Comments for Planning Application 20/00934/FUL

Application Number: 20/00934/FUL

Address: Land To The Rear Of The George Inn 5 Sandford Road Littlemore Oxford Oxfordshire OX4 4PU

Comment: Comments on behalf of Oxfordshire County Council - Oxford Locality (Transport Development Control).

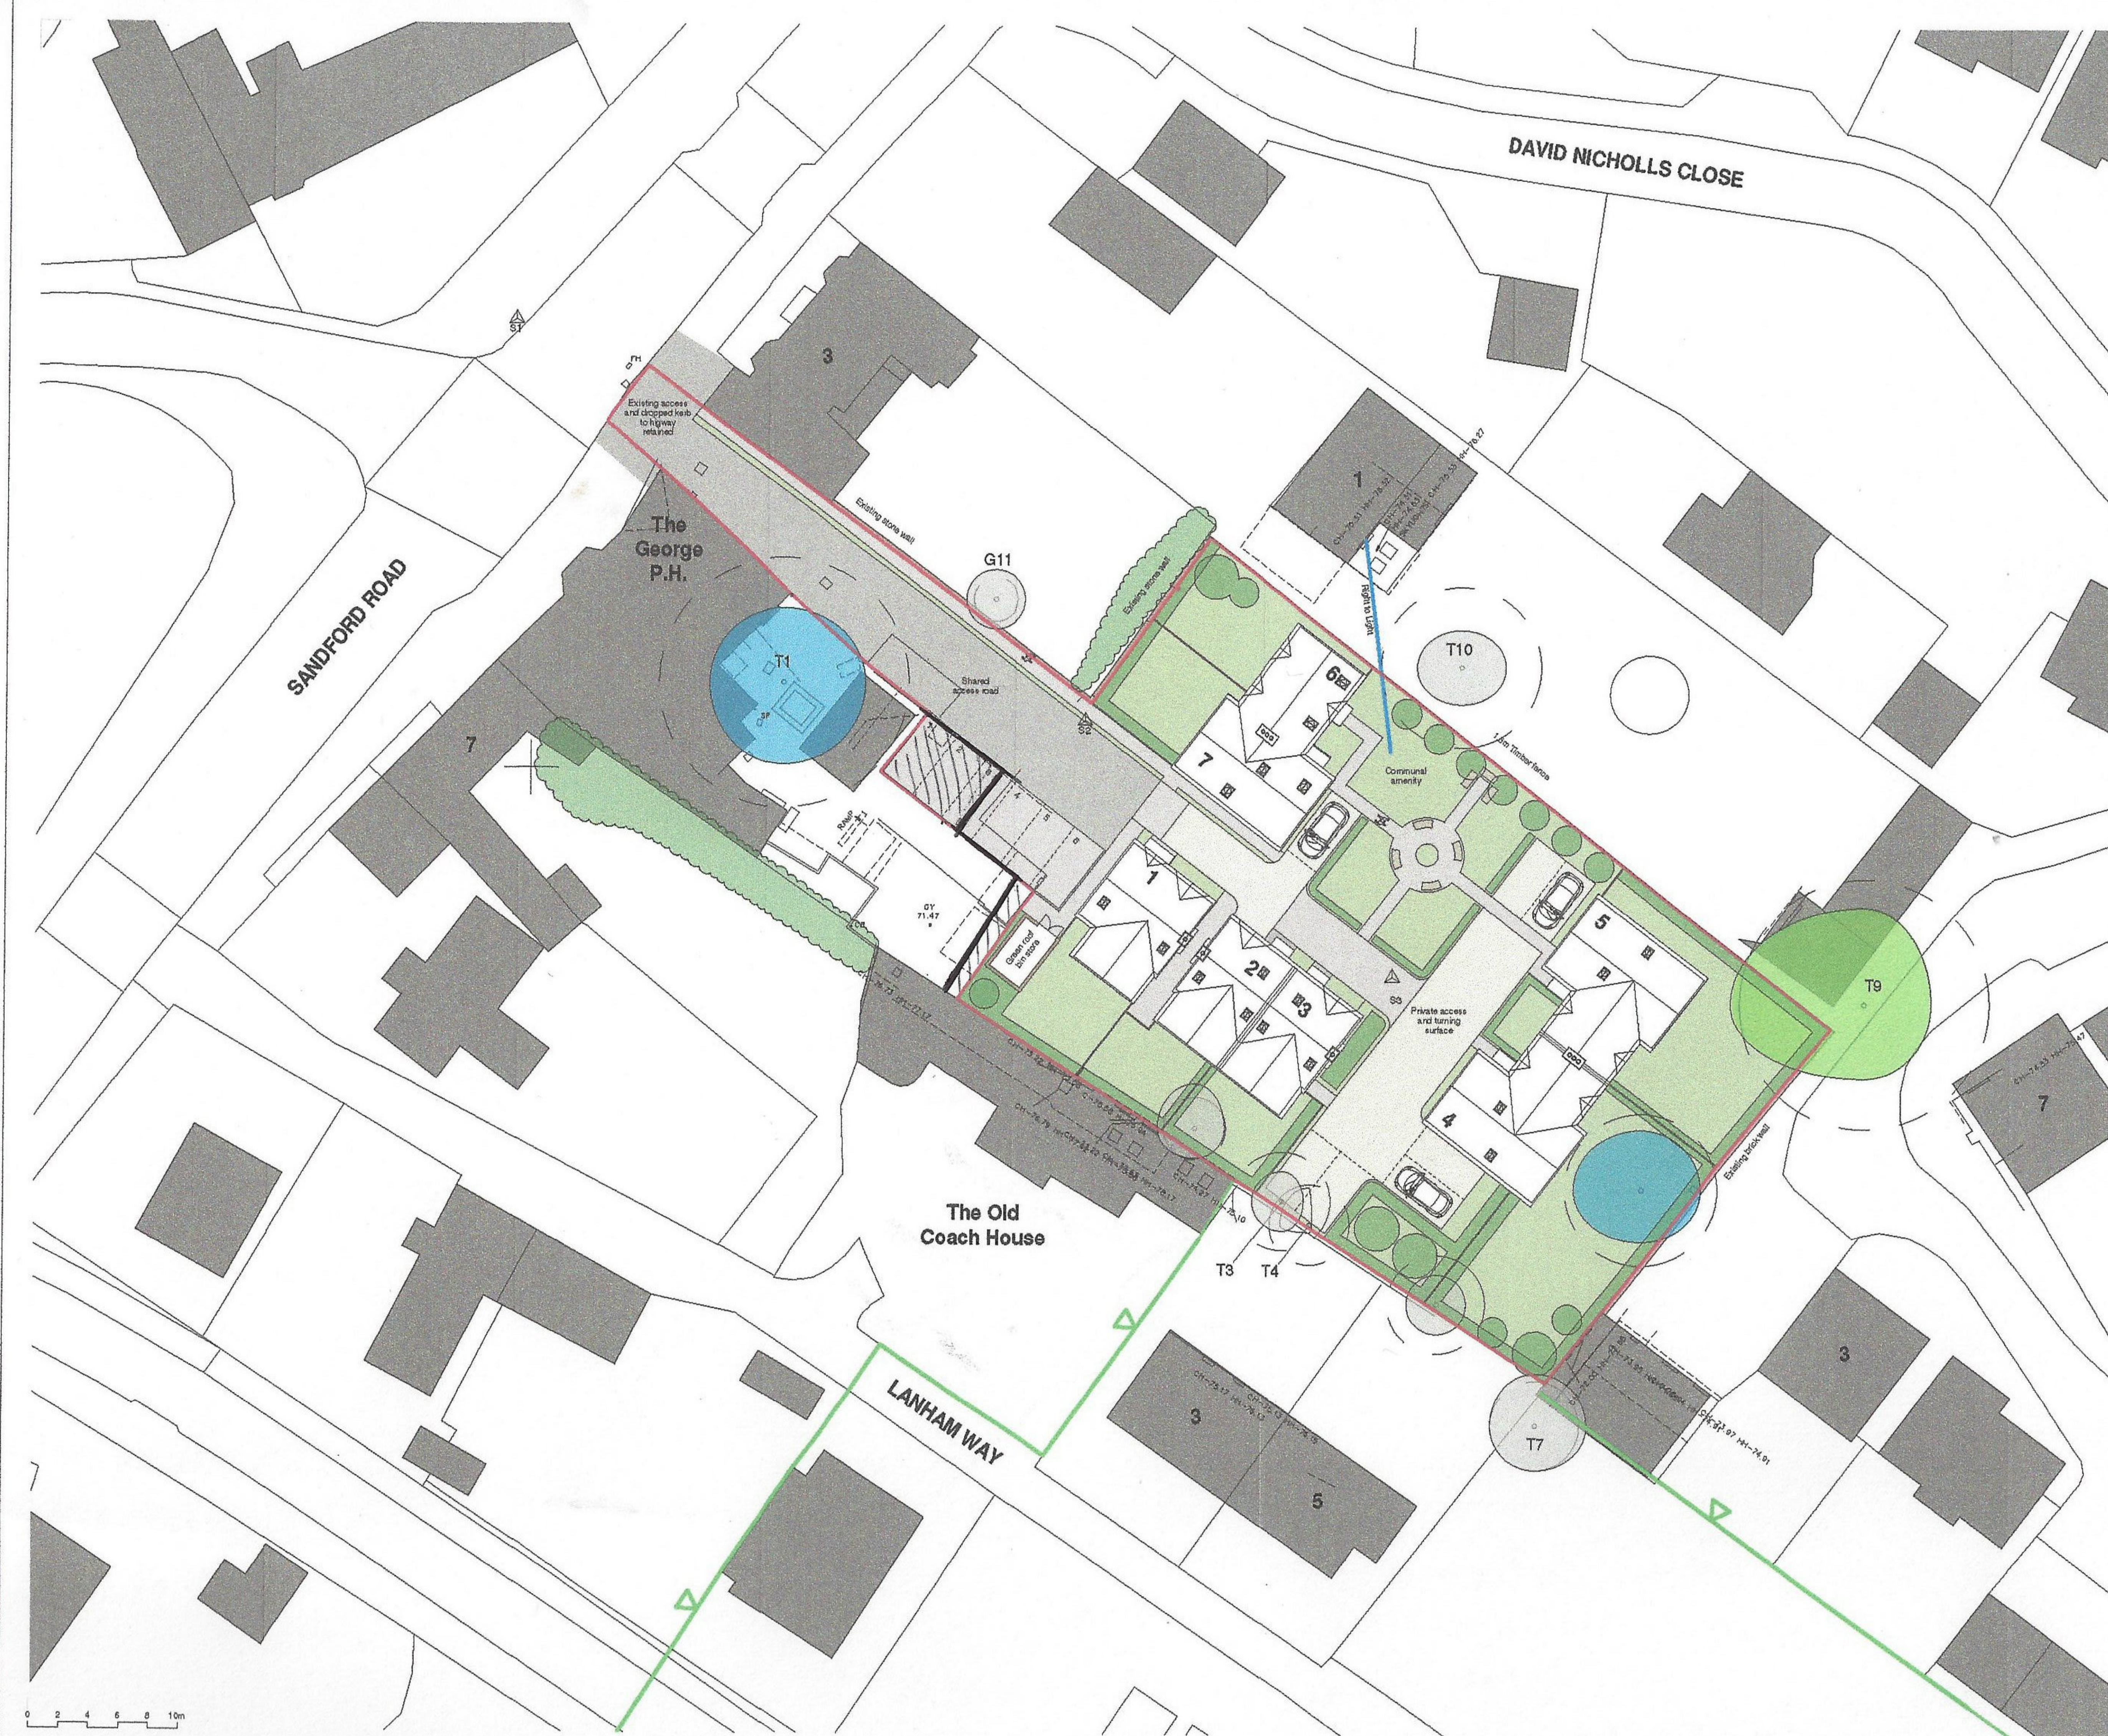
The provision of 12 bays for the proposed units is therefore above the maximum standards and not acceptable. The application also states that The George will retain 7 bays, however the submitted plans appear to show only 5 bays within their land and the red line going through a parking bay which is clearly not acceptable. No information has been provided as to how the 7 bays meet the needs of the pub or the impact the loss of match day and school parking will have on the highway network. Despite the application stating there are currently 19 parking bays behind The George, no parking survey has been undertaken and it could well be a higher number.

The Transport Statement states in Paragraph 7.11 that "The car parking spaces provided will be a minimum dimension of 5.0m x 2.5m with clear minimum manoeuvring space of 6.0m as advised within the standards.". The submitted plans appear to show the parking bays only measuring 4.8m x 2.4m with the aisle between parking bays measuring 5.8m. This is not in line with Oxfordshire County Council's Parking Standards for New Residential Developments document and as such an objection is raised.
